2 April 2026

SSD-81662708 Cross Link Industrial Estate

The Civil Infrastructure and Servicing Report prepared by at&I Issue 5 dated 26 February 2025 includes the following addressing whether electricity services are available and adequate for the proposed development.

Figure 20 – Extract of proposed architectural drawings showing the SSDA Masterplan.

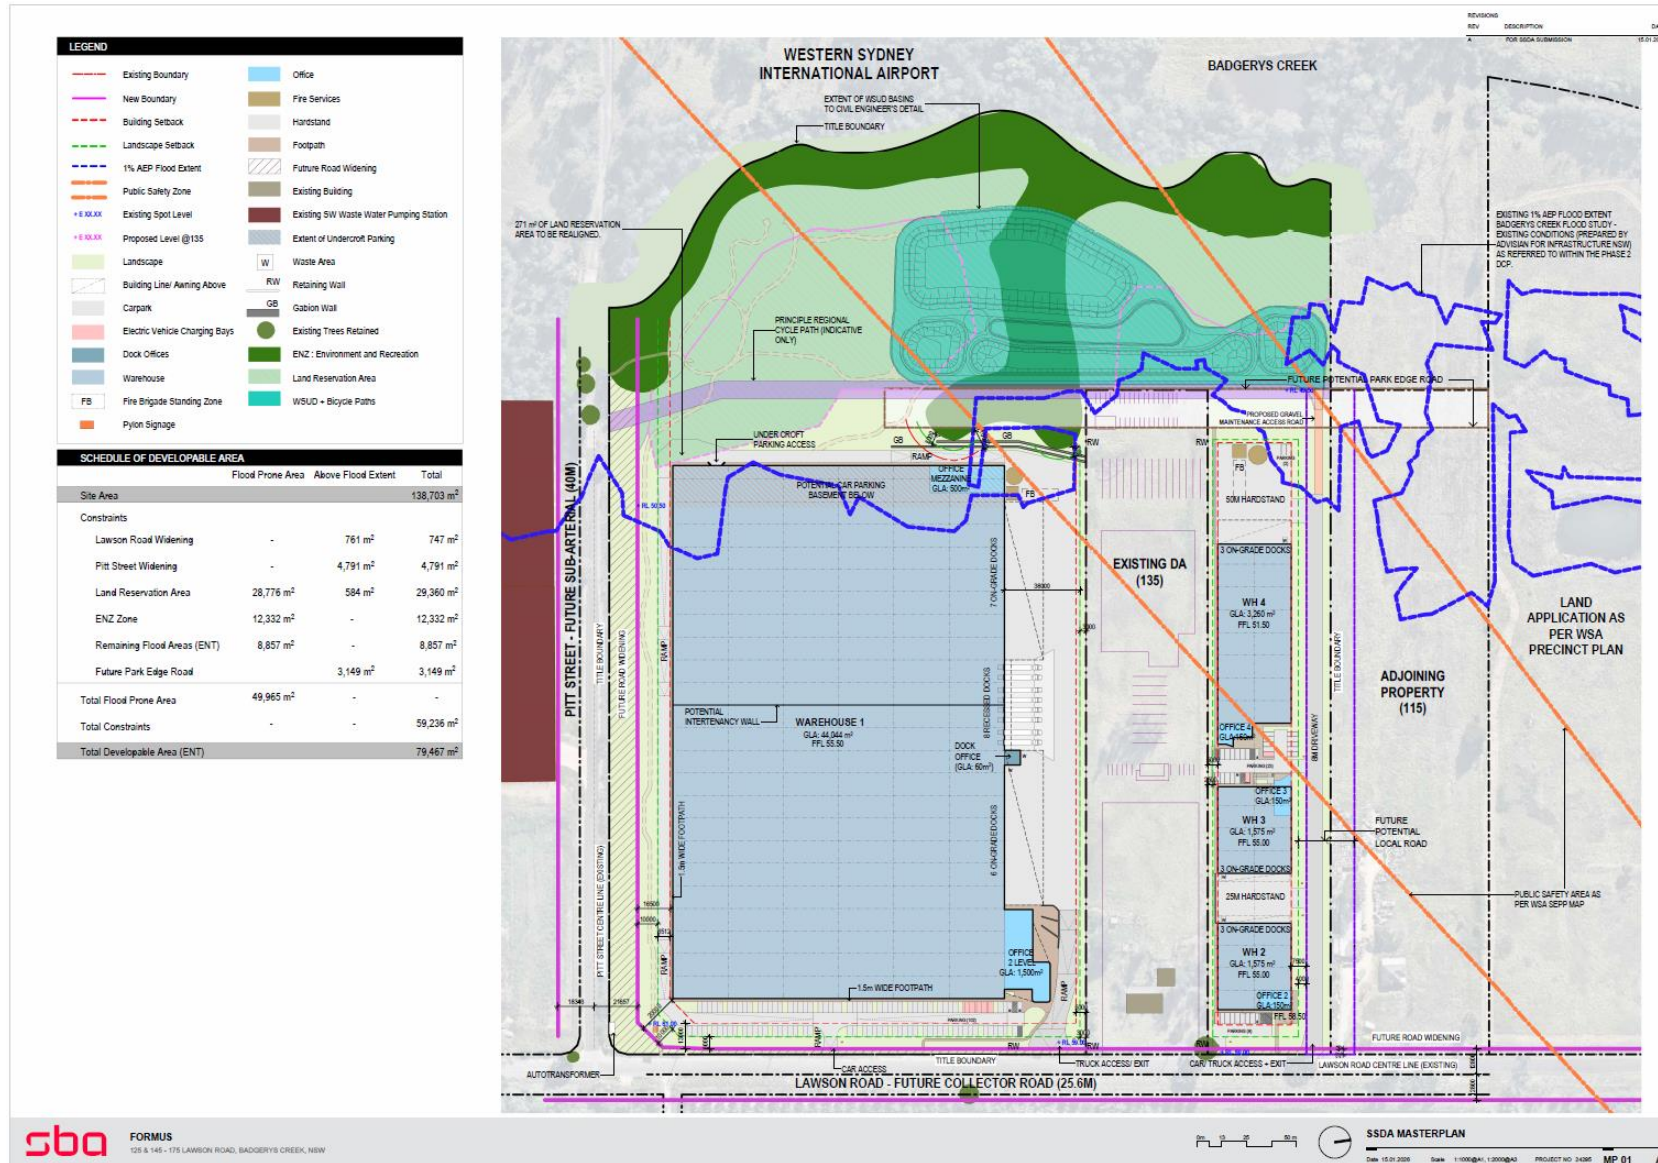
It does not appear to address the electricity distribution within the Estate,

The Architectural Plans do not appear to show provision for any padmount substations. Any required padmount substation/s will need to be located within the property (in a suitable and accessible location) and be protected (including any associated cabling not located within a public road / reserve) with an appropriate form of property tenure as detailed in the attached copy of Endeavour Energy's 'Land Interest Guidelines for Network Connection'.

Generally it is the Level 3 Accredited Service Provider's (ASP) responsibility (engaged by the developer) to make sure substation location and design complies with Endeavour Energy's standards the suitability of access, safety clearances, fire ratings, flooding etc. If the substation does not comply with Endeavour Energy's standards, the applicant must request a dispensation.
